WAYNFLETE LOWER SCHOOL - ADDENDUM #2

date: Monday, February 06, 2017
project: Waynflete Lower School Addition & Renovations, 2013-0050
prepared by: Austin Smith Scott Simons Architects
to: Cordelia Pitman Wright Ryan Construction
Rick Bergeron Wright Ryan Construction
Luke Dione Wright Ryan Construction
Anne Hagstrom Waynflete School
Patrick Boure Waynflete School
Phil LaClaire PML Project Management

Subject: Addendum #2 to Bid Documents of January 12, 2017

**6 RECEPTION DESK SECTION**  
SCALE: 1" = 1'-0"

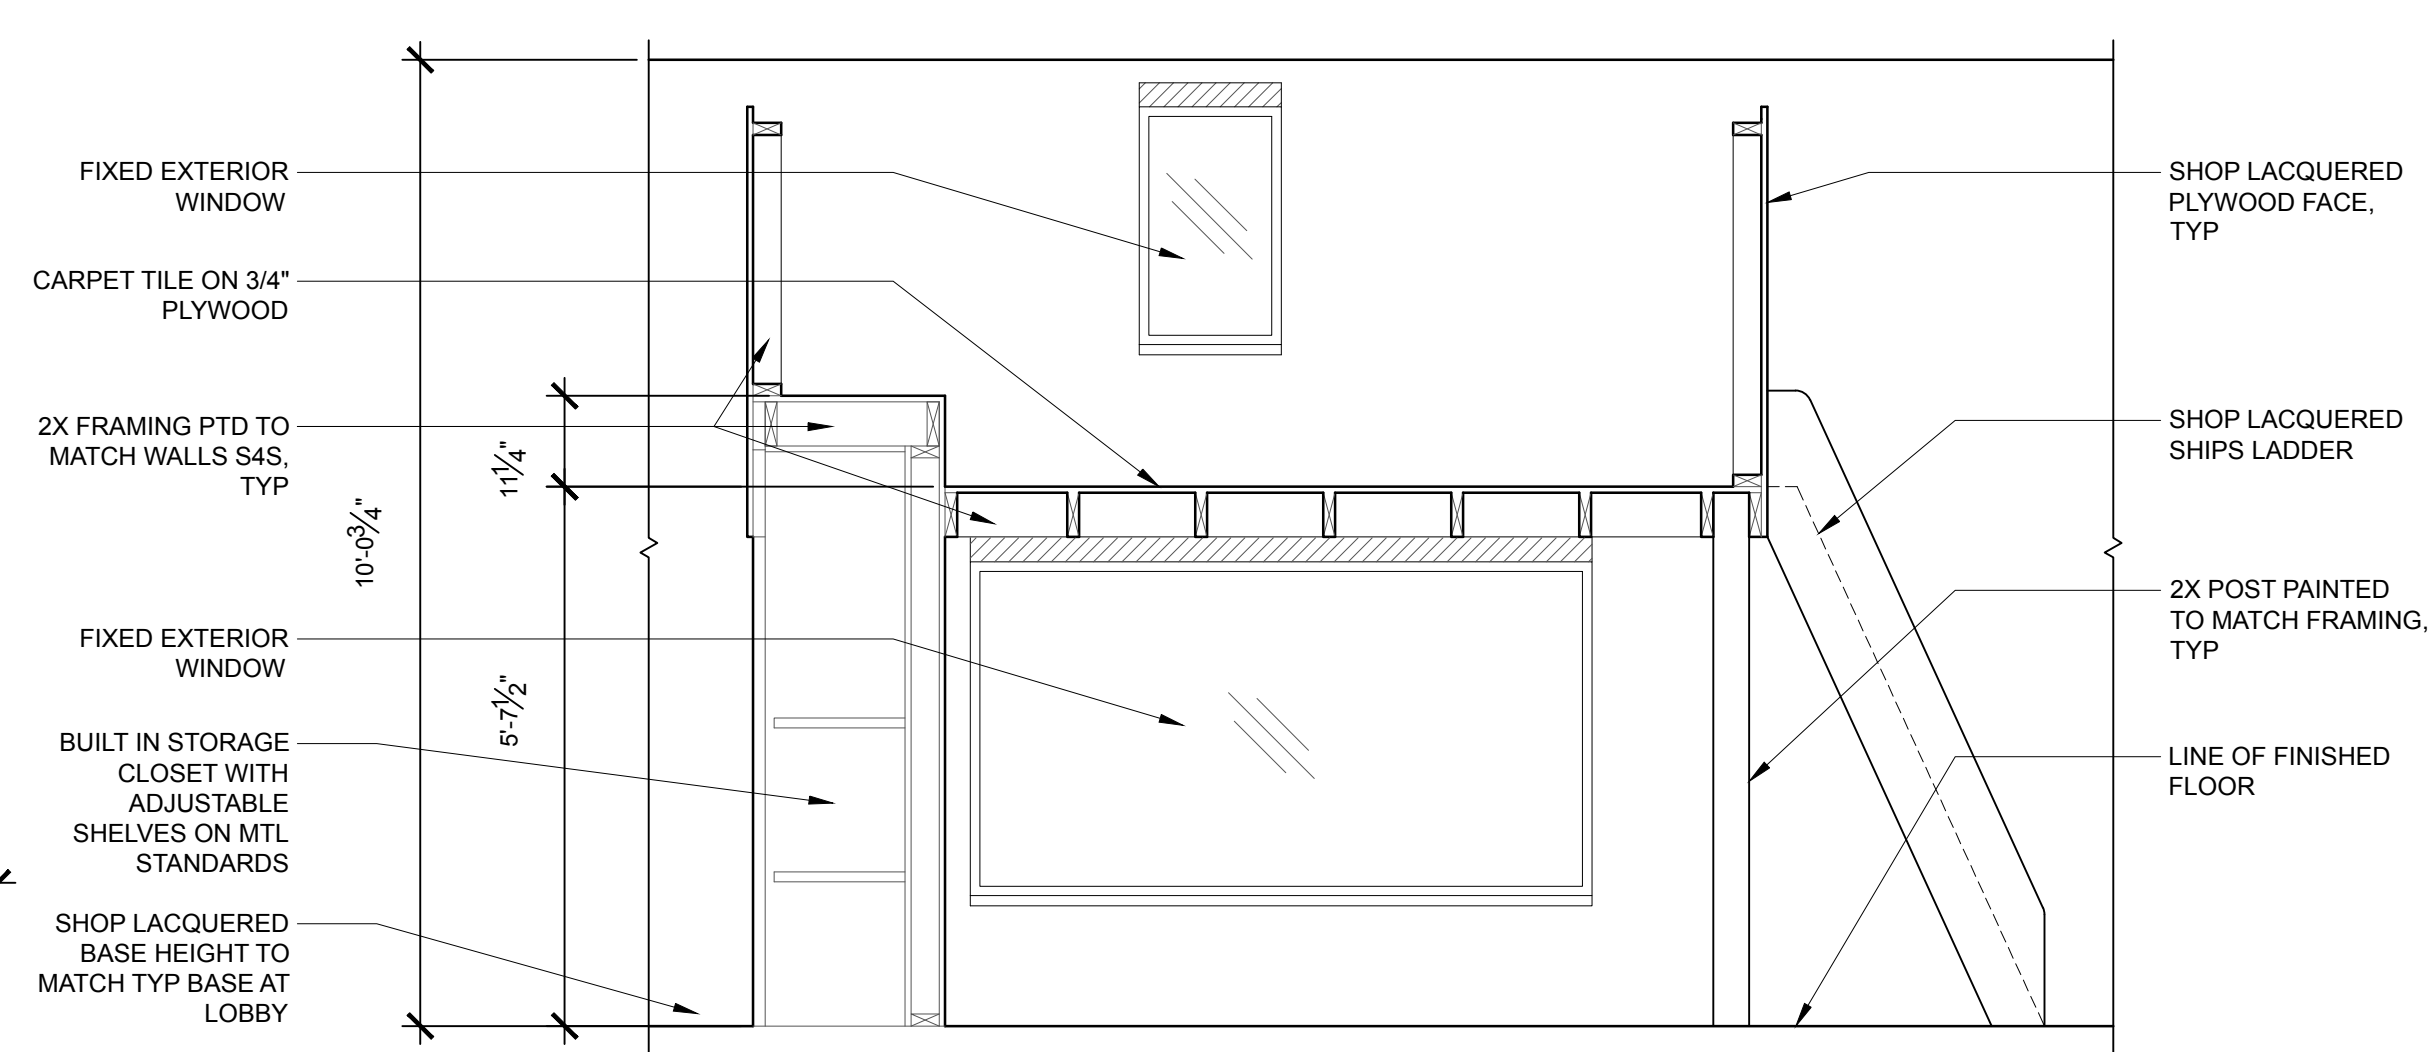
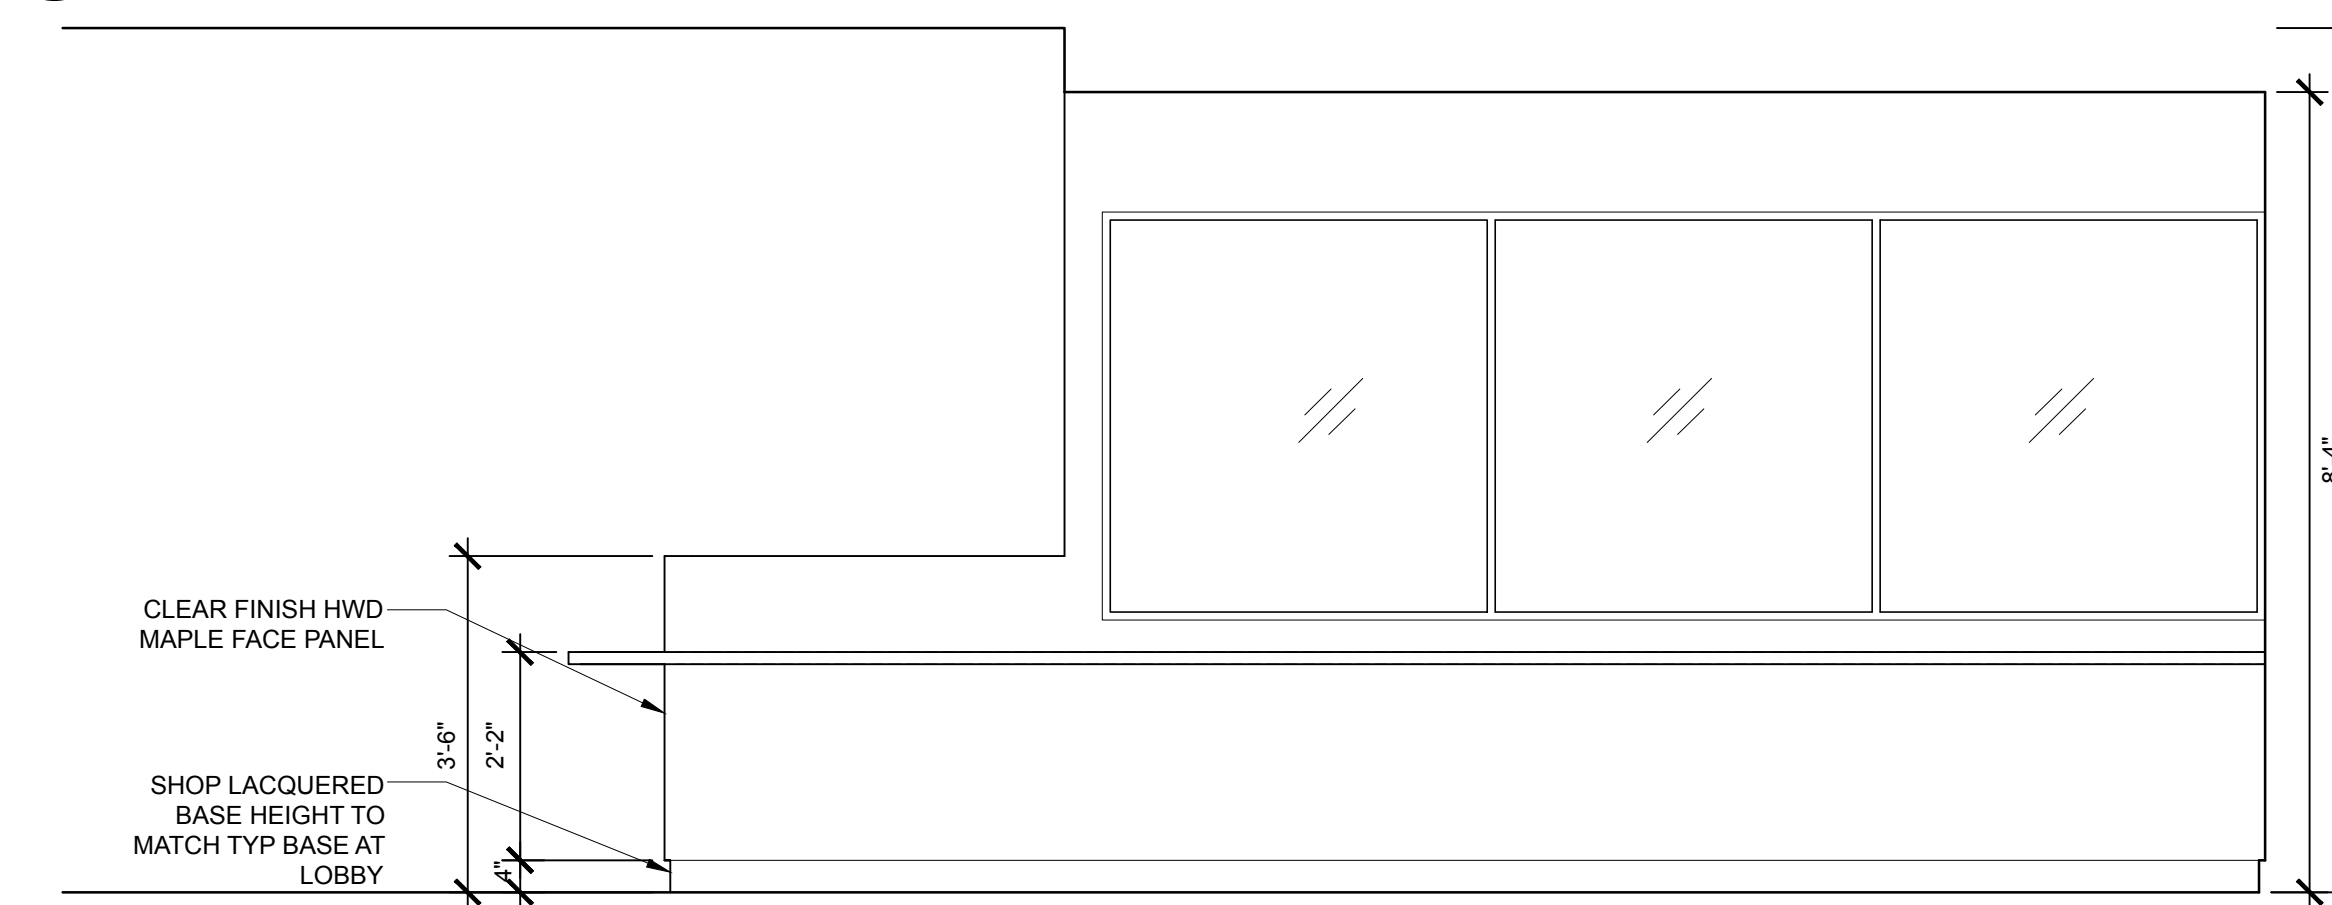
- 2-Q20 Question 20 Q: Drawing A102: Will the Resource Deck 120B require metal framing and GWB?
A: This desk to match assembly of Reception Desk. See 6/A532, sim.

A411R

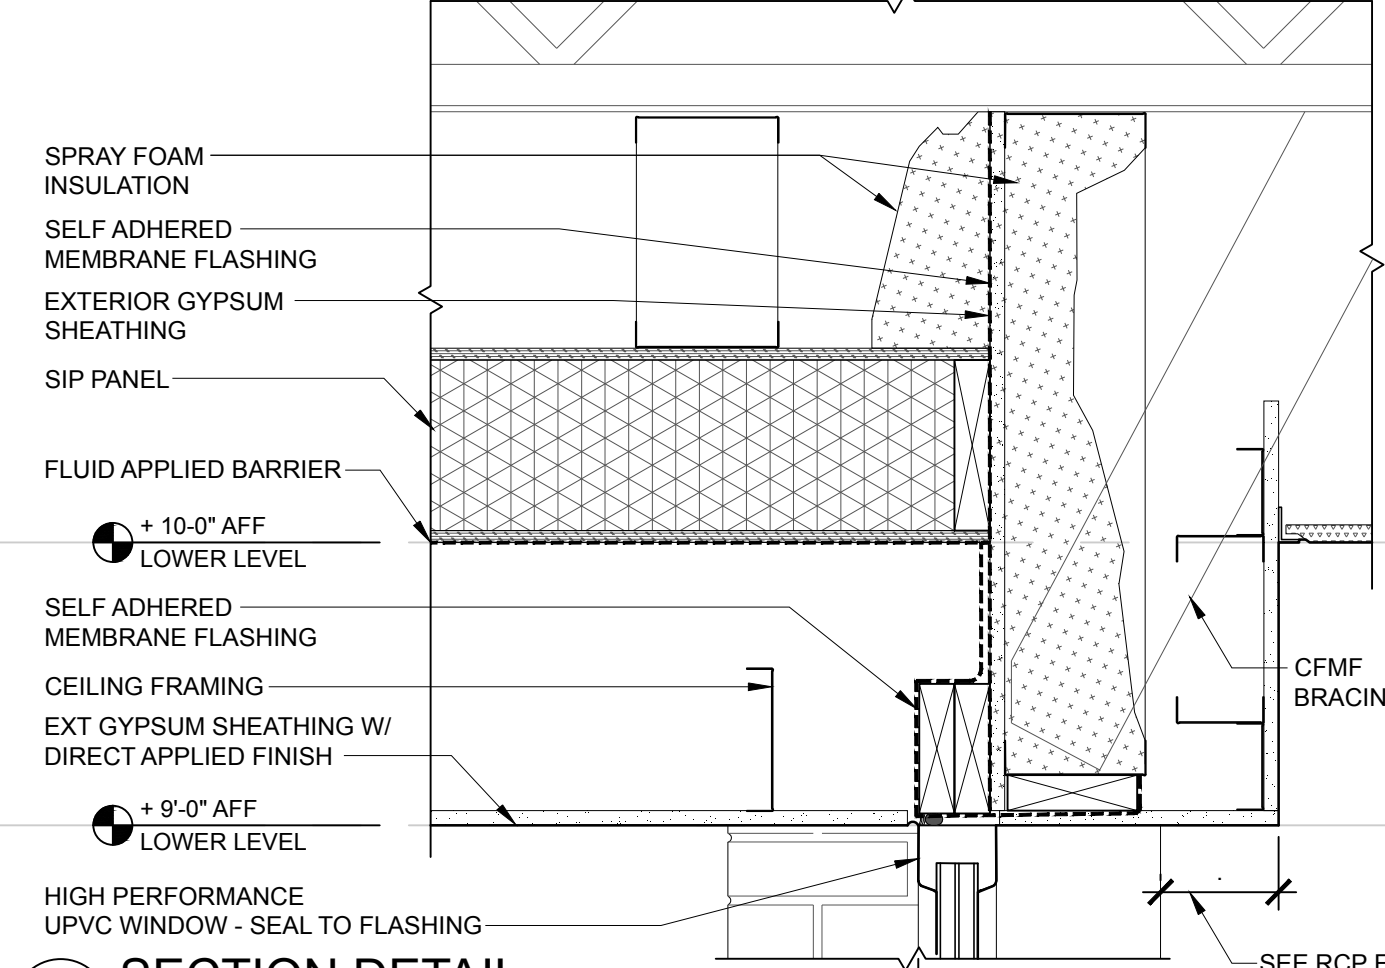
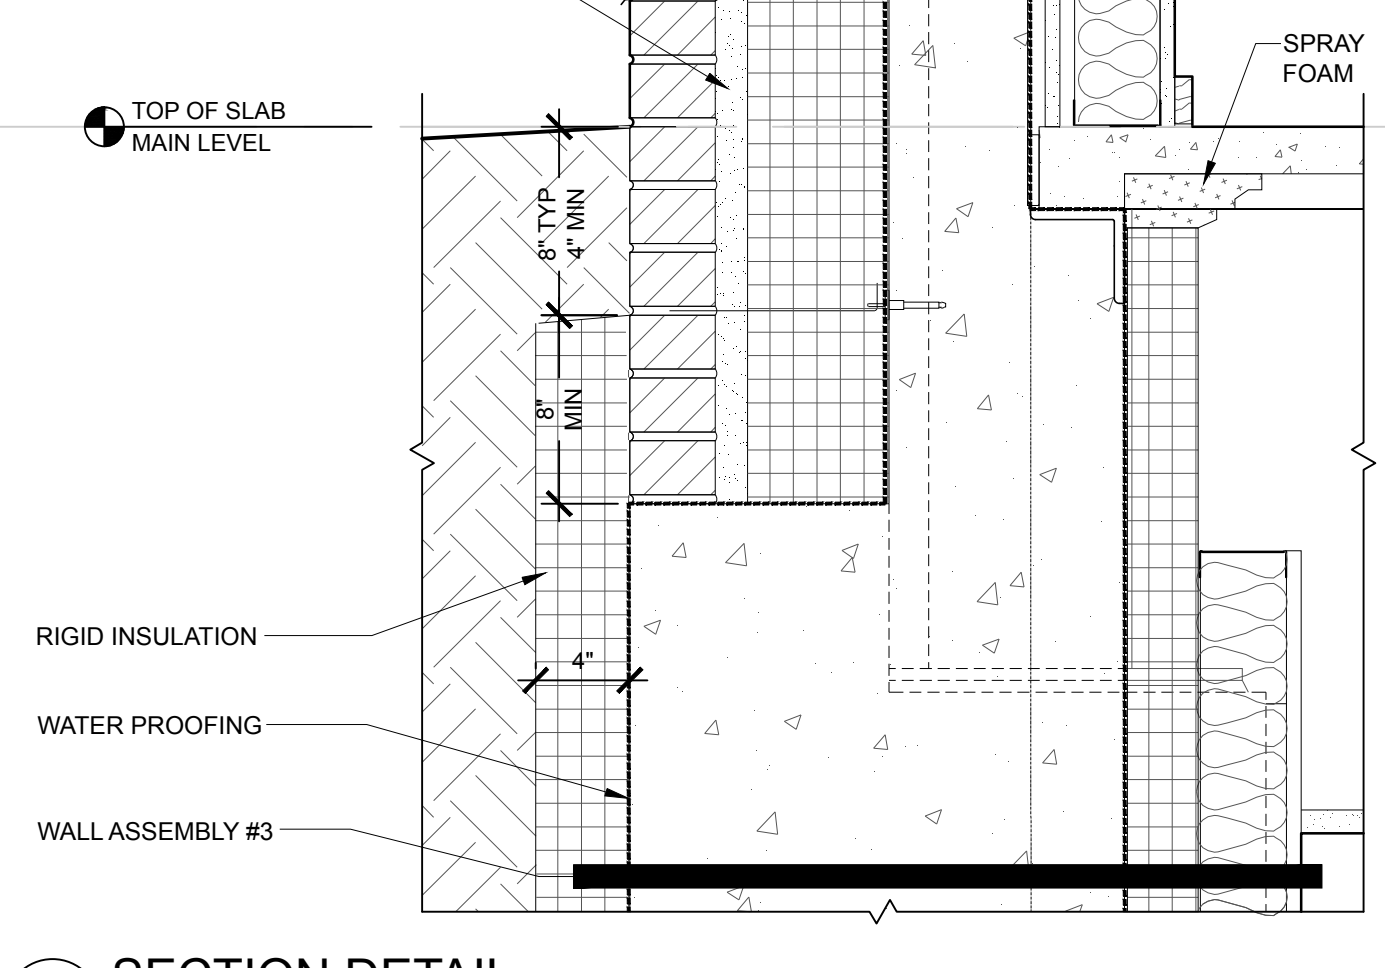
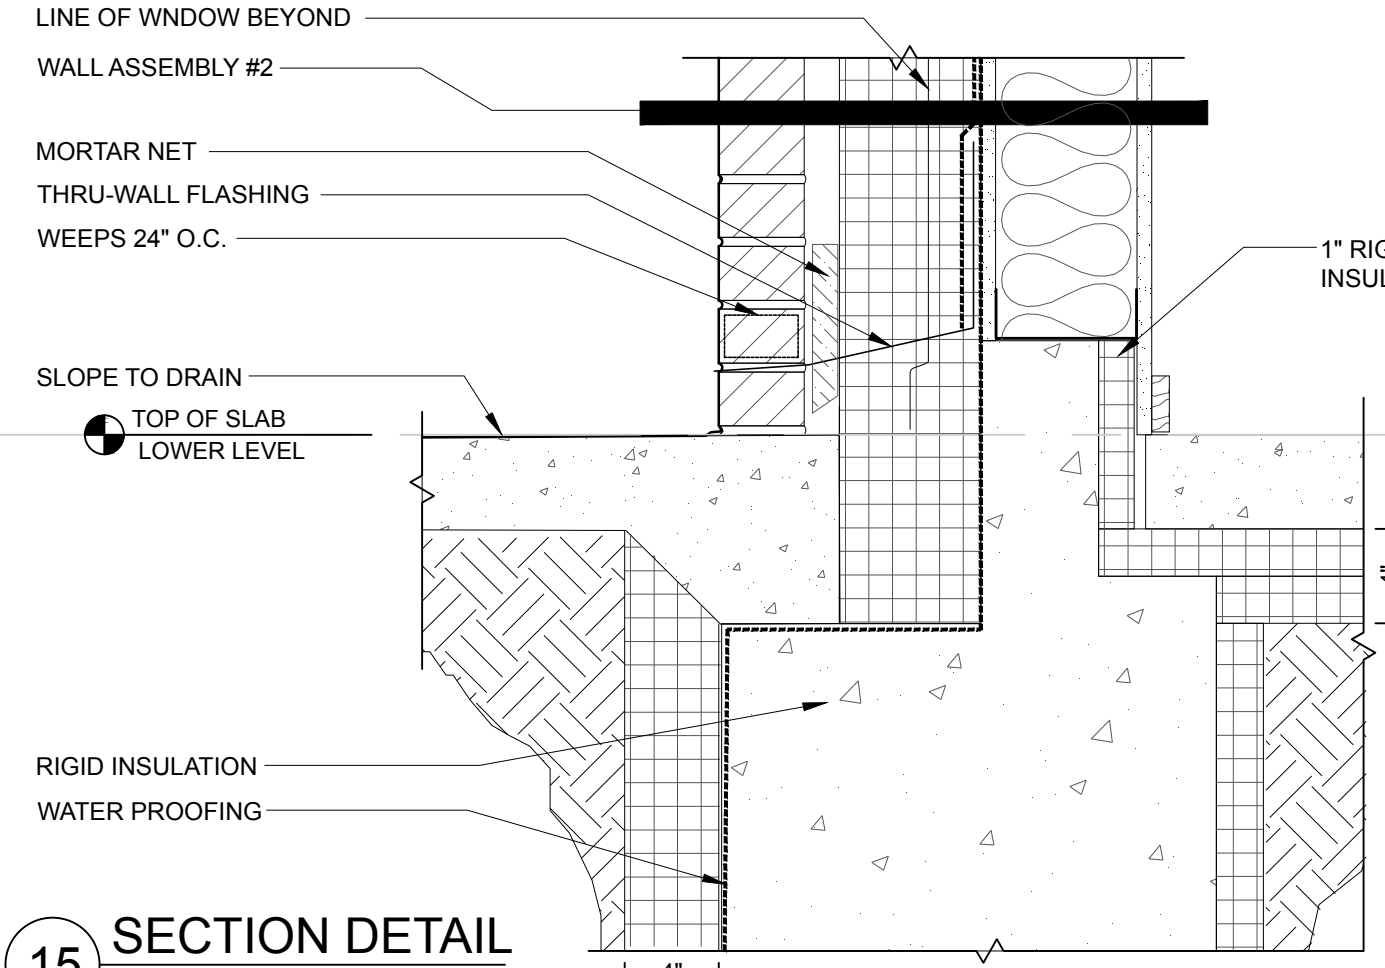
A. The Contract Documents call for fully-functional systems. Installation of the generator on the roof is a matter of Contractor's means and methods.
- 2-Q31 Question 31 Q. The plans (A411 Section 11 and 15) shows metal through wall flashing with a leg that runs up wall 8" but Specs 042000 2.9A.1 calls for back edge turned up 1.5". Please Clarify

A. Provide 1.5" back edge at a minimum, unless otherwise indicated in dwgs.
- 2-Q32 Question 32 Q. Windows 03, 07, & 10 have masonry sills but there is no detail that shows how it is to be constructed. Please clarify these sills or provide a detail.
